**WEST SUSSEX COUNTY COUNCIL
FLOOD RISK MANAGEMENT CONSULTATION**

DATE: 9th July 2018

PLANNING REFERENCE: CM/16/18/PL

LOCATION: Land To The Rear of Bairds Farm Shop, Crookthorn Lane, Climping

Appendix H - Proposed Drainage Strategy

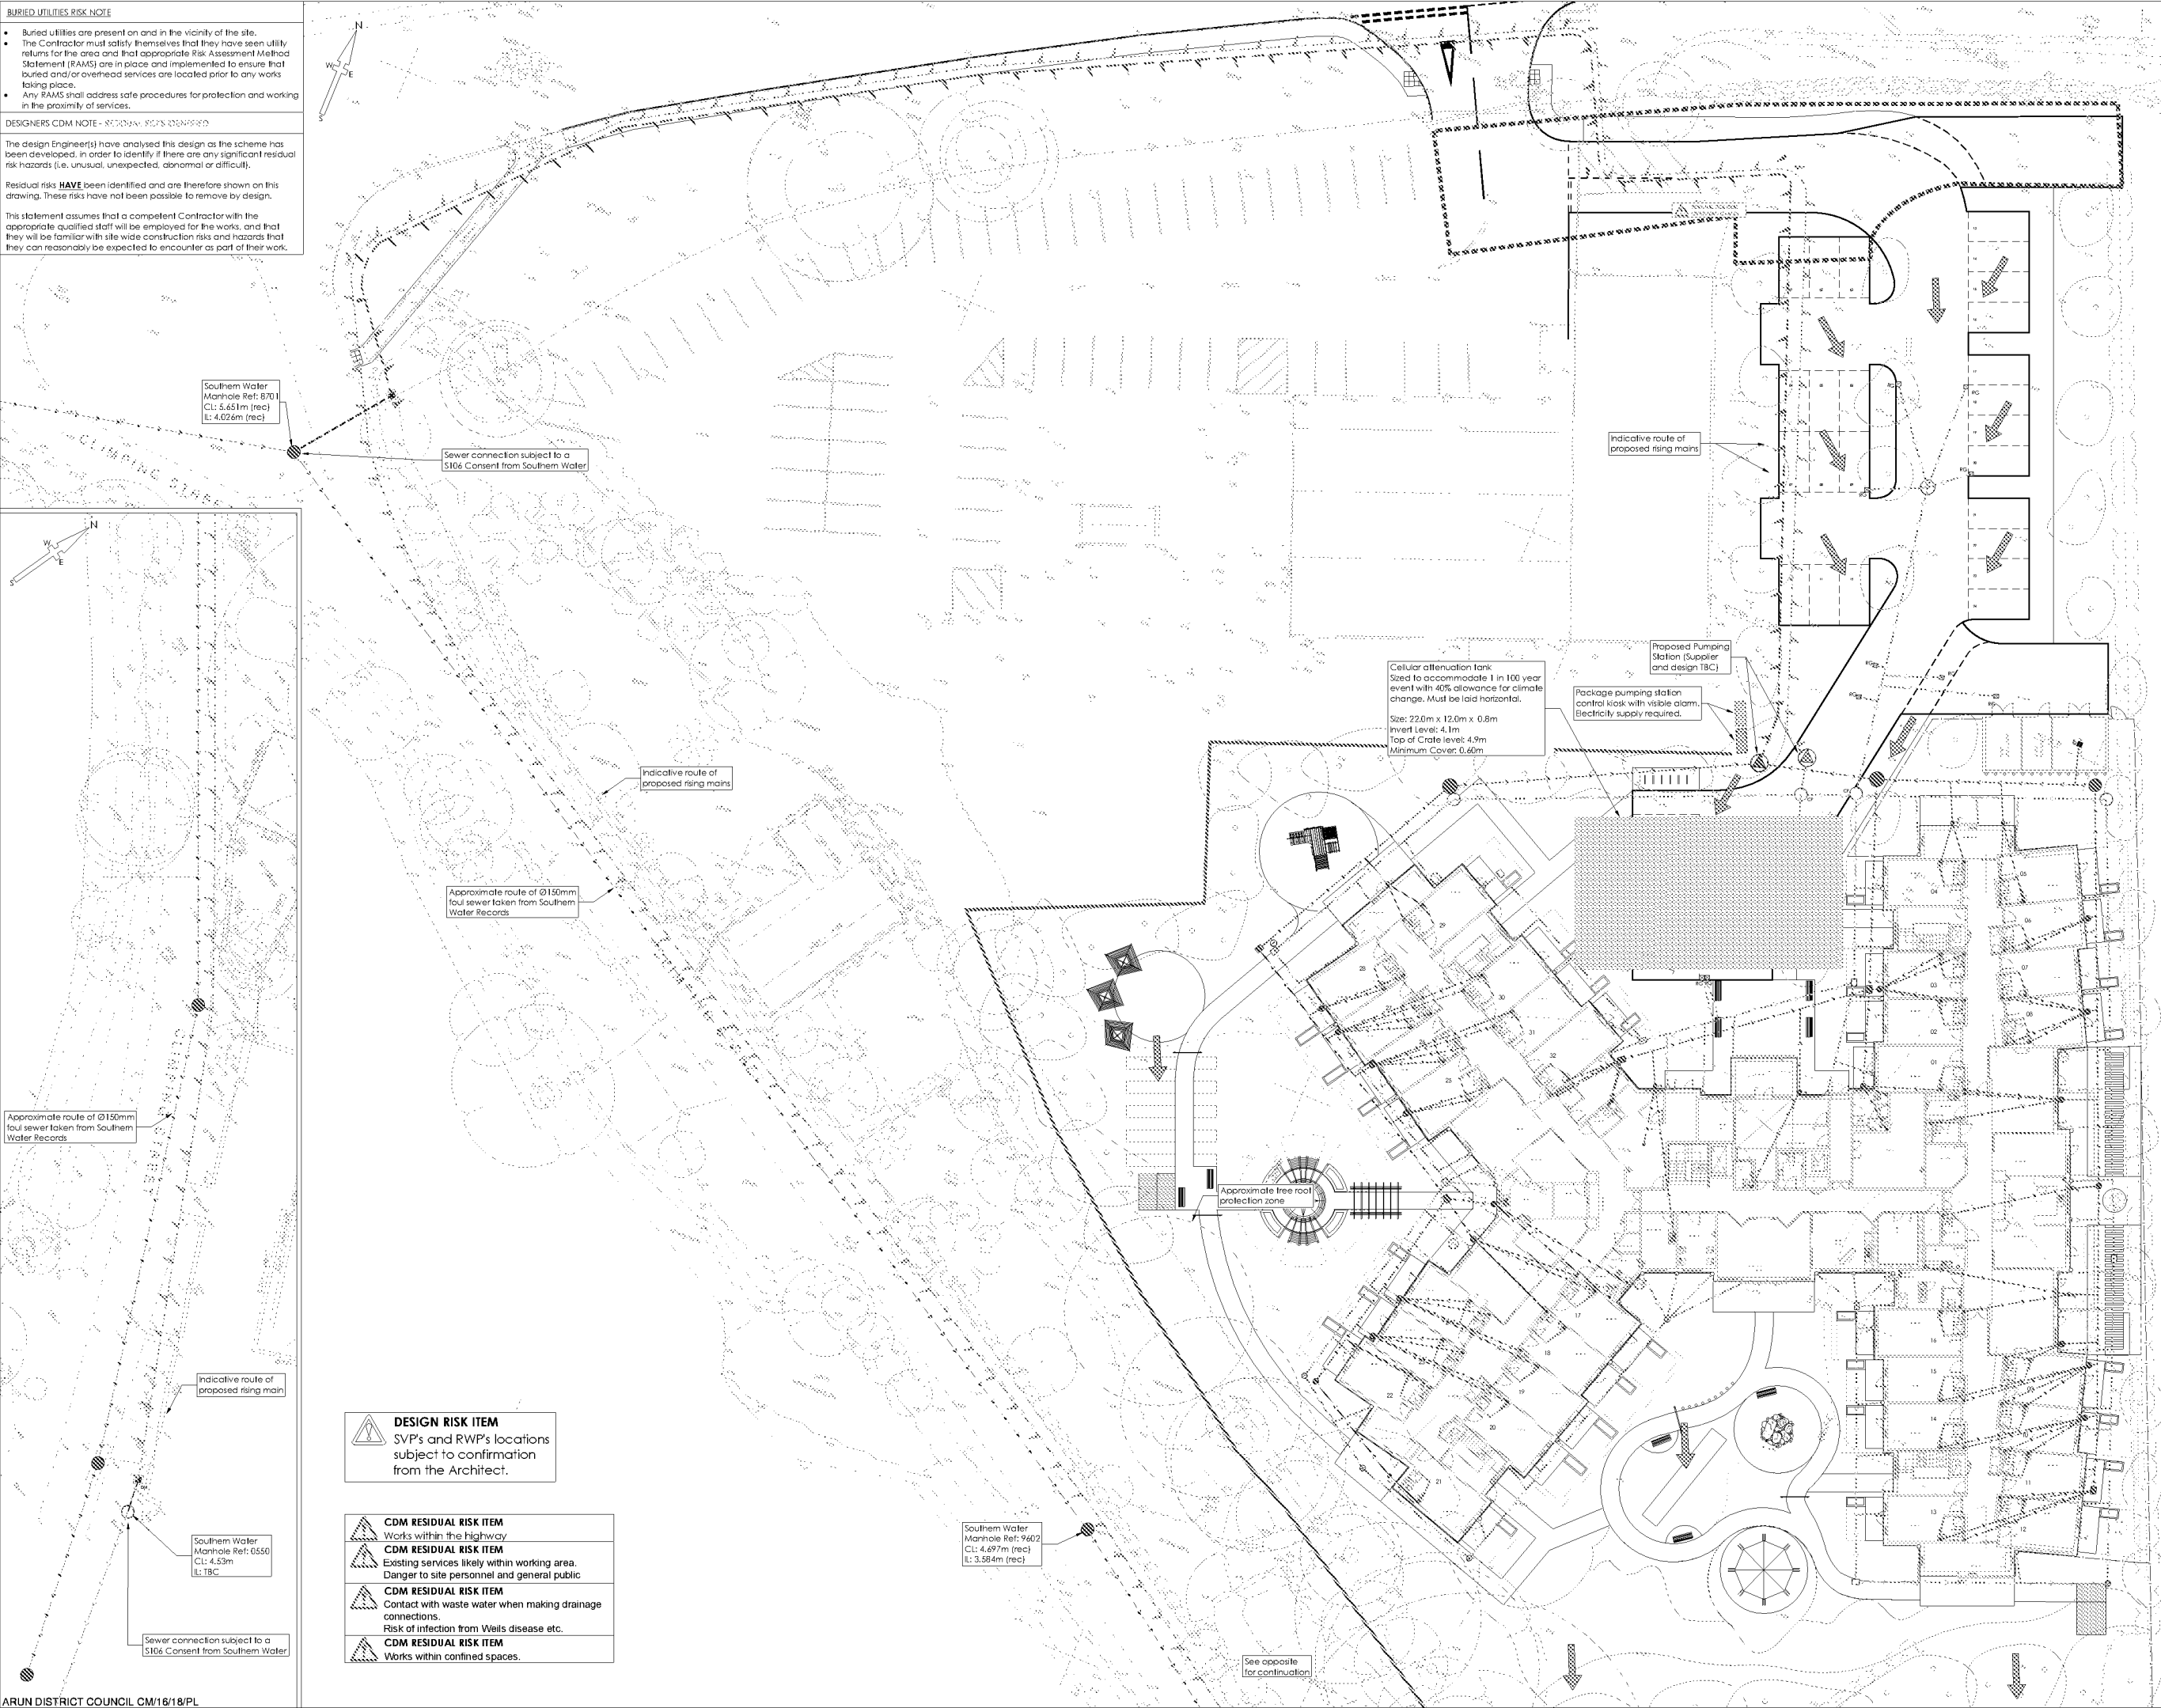
The FRA/Drainage Strategy included with this application proposes that green roofs, below ground attenuation and a surface water pumping station would be used to control the surface water runoff from the site.

The FRA states that there is no infiltration potential for the site. Full ground investigation (winter groundwater monitoring), in consultation with the District Council Drainage Engineer, would be required to determine whether infiltration methods are possible.

It is recommended that this application be reviewed by the District Council Drainage Engineer to identify any site specific land use considerations that may affect surface water management and for a technical review of the drainage systems proposed including the surface water pumping station as this is not considered a sustainable option.

Following the SuDS hierarchy and the spirit of SuDS implementation, betterment for surface water systems on the new developments should be sought. This could include retention at source through permeable paving and swales prior to disposal to reduce peak flows. SuDS landscaping, could significantly improve the local green infrastructure provision and biodiversity impact of the developments whilst having surface water benefits too.

Development should not commence until finalised detailed surface water drainage designs and calculations for the site, based on sustainable drainage principles, for the development have been submitted to and approved in writing by the Local Planning Authority. The drainage designs should demonstrate that the surface water runoff generated up to and including the 100 year, plus climate change, critical storm will not exceed the run-off from the current site following the corresponding rainfall event.
